Your Ref: OWPC18907
Our Ref: FG/95/18/HH 04-05-2018
Please ask for:
Andrew Wood

Two storey front extension, side/front first floor extension & replacement garage.
25 South Drive Ferring

AR-102-202

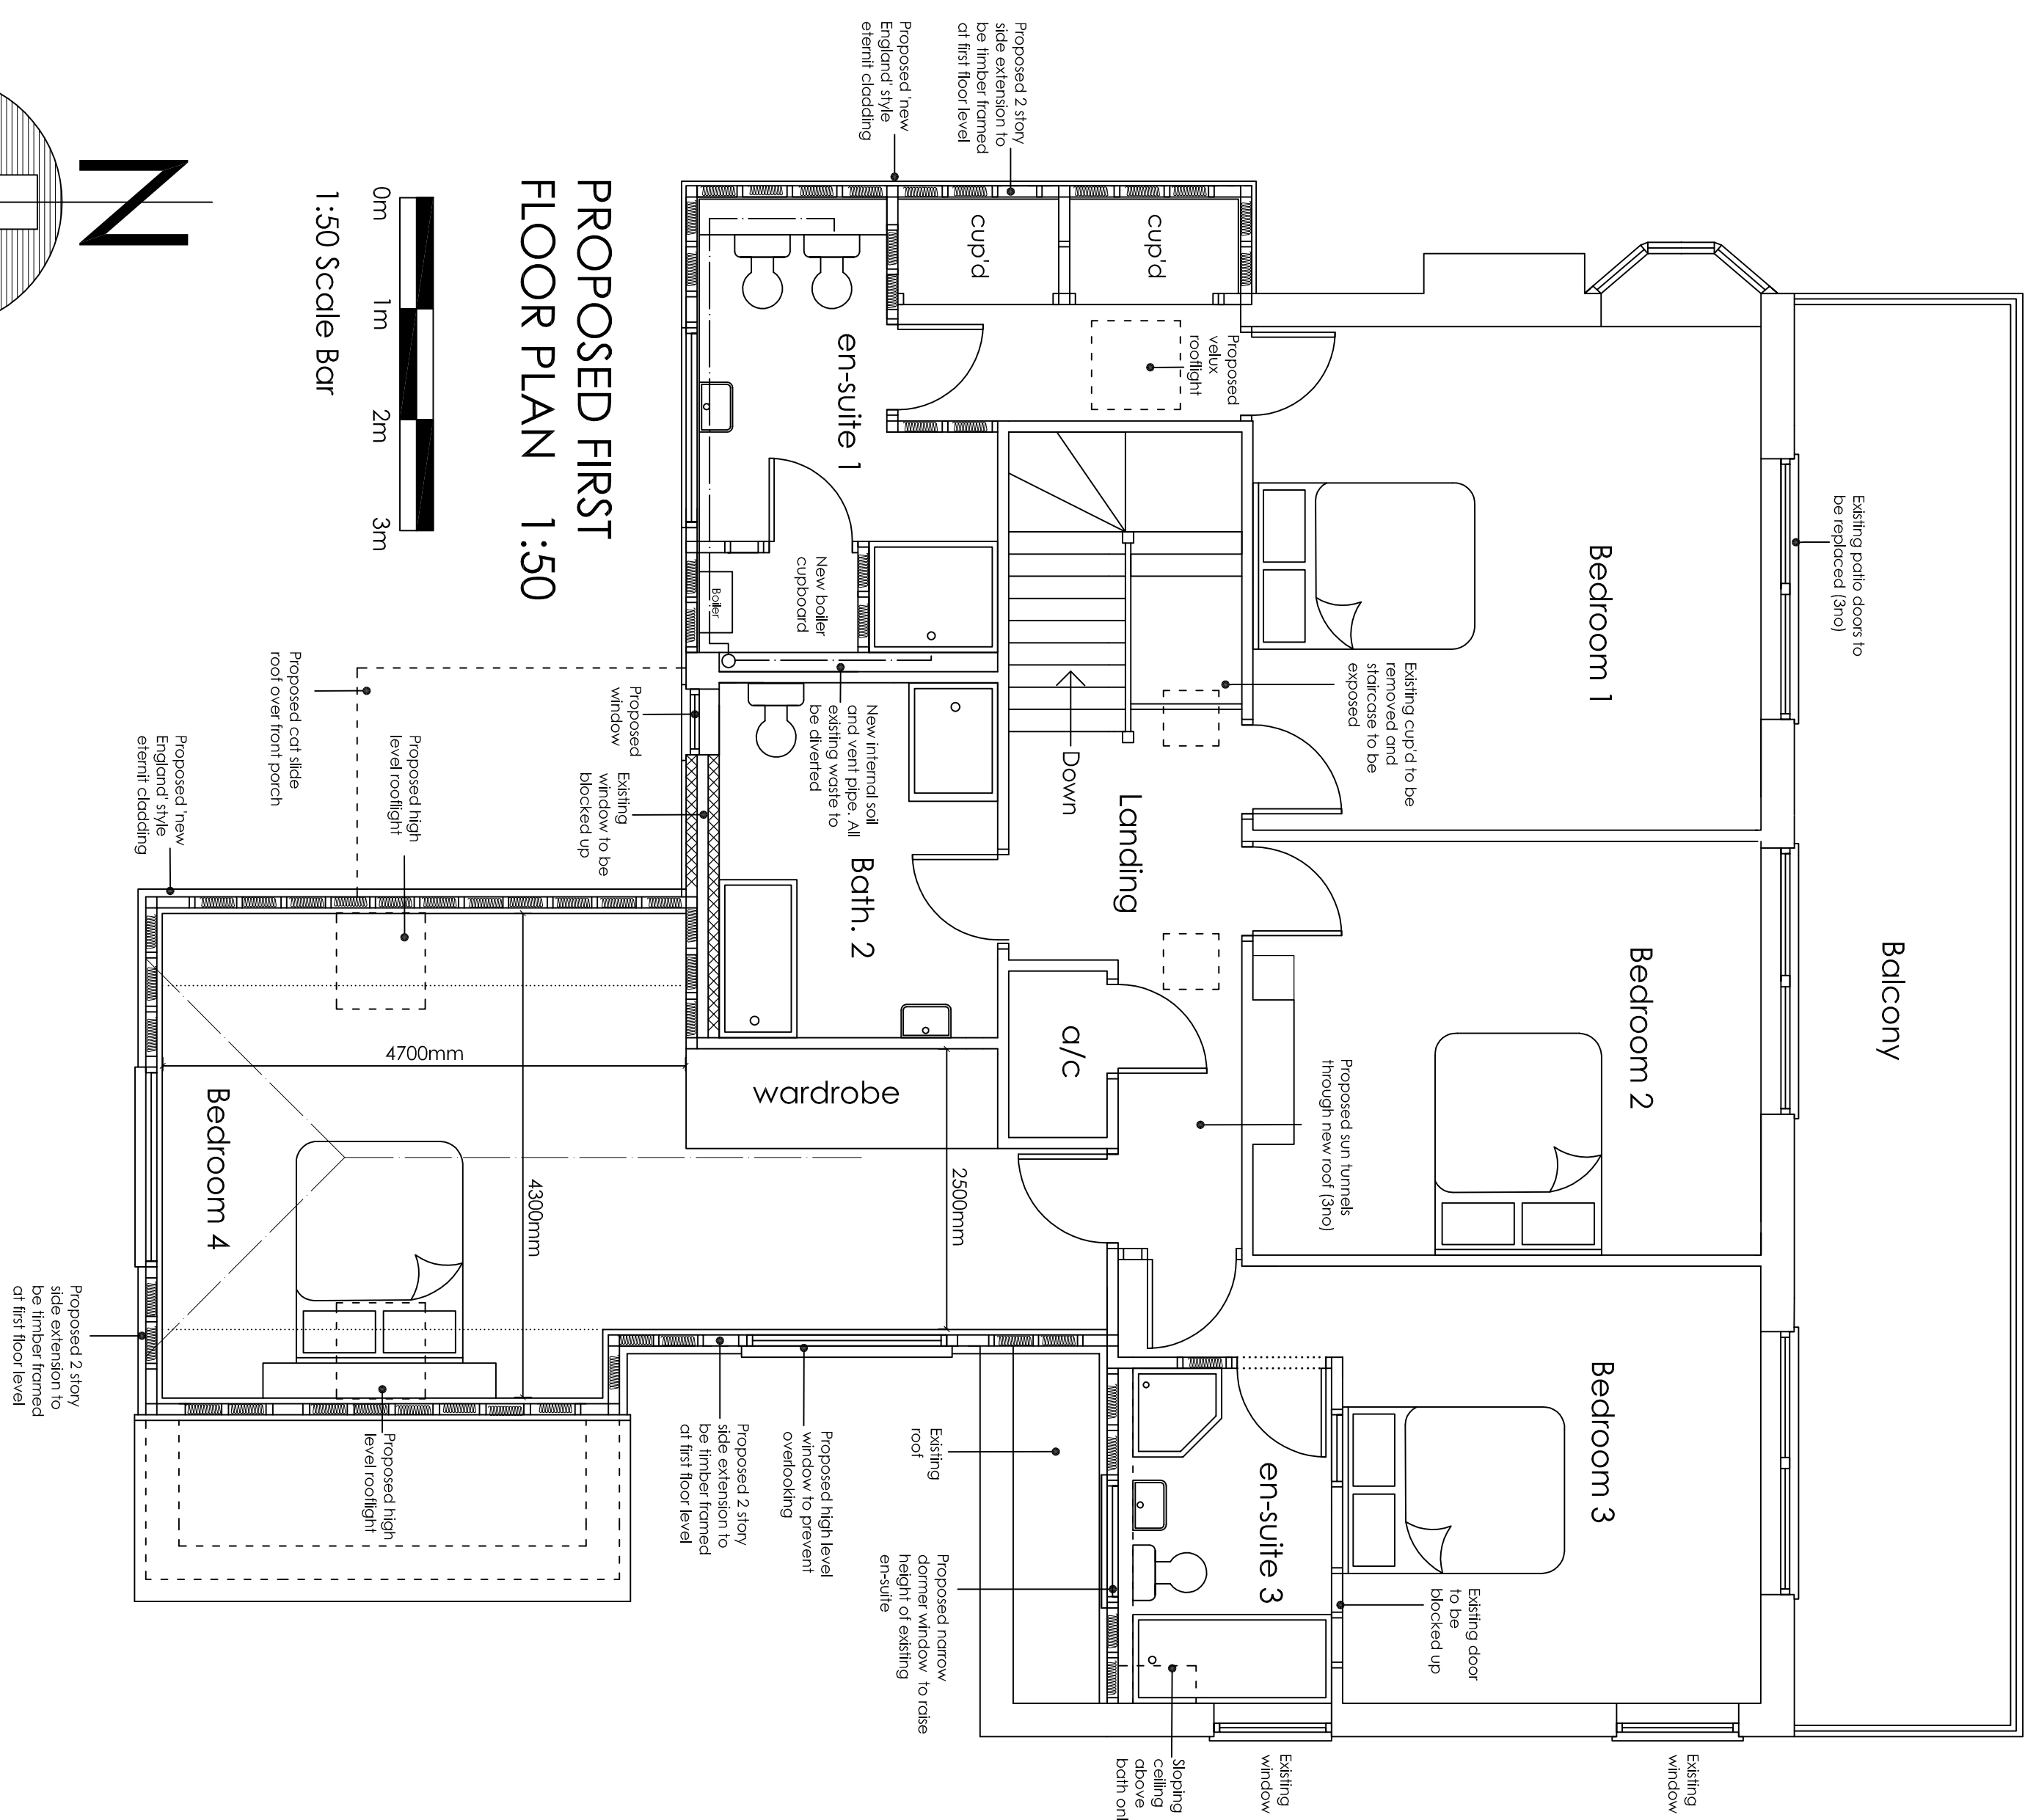
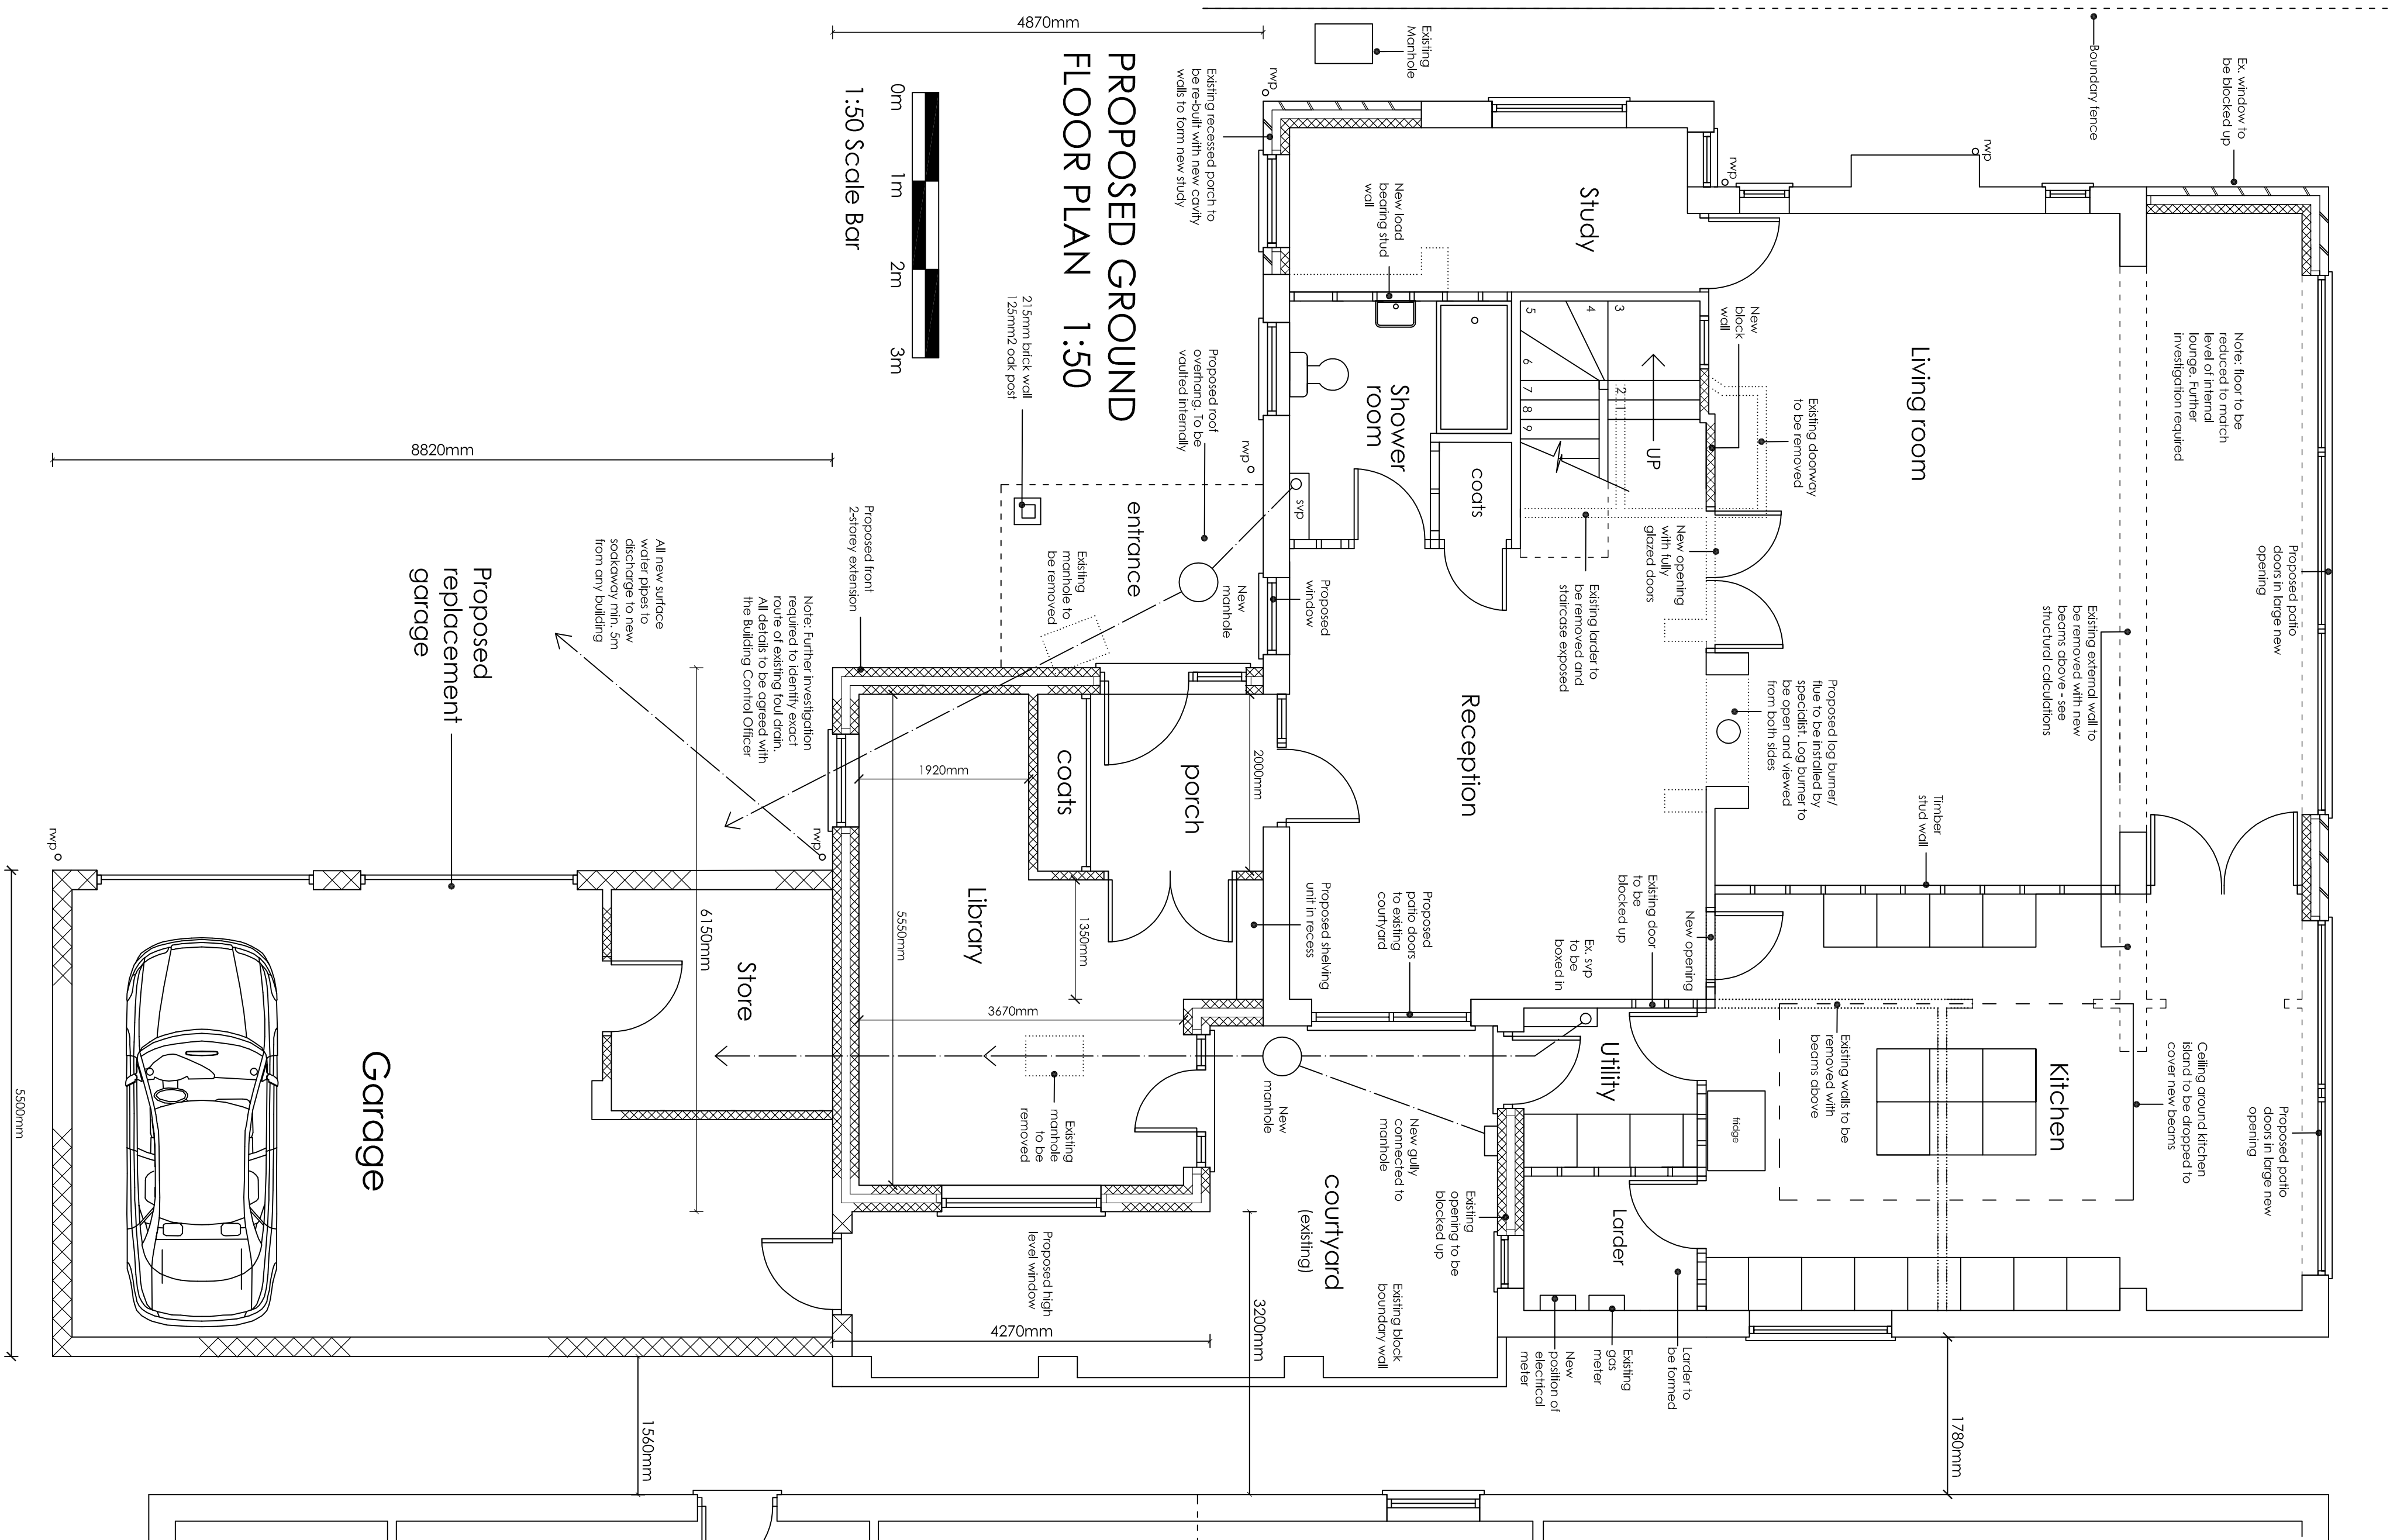
With regard to the proposed 2 storey extension to the front of the property we object to the high level window to Bedroom 4 on the West Elevation.

In the planning statement it mentions the 2.6m high boundary wall remaining and on the plans that this window is high level to prevent overlooking. On site, however, it can be seen that this window will indeed overlook our property in that it will have a line of sight over this wall and directly into our kitchen. This will obviously lead to a Loss of Privacy.

If this window were to be non opening and of obscure glass we would have no further objection.
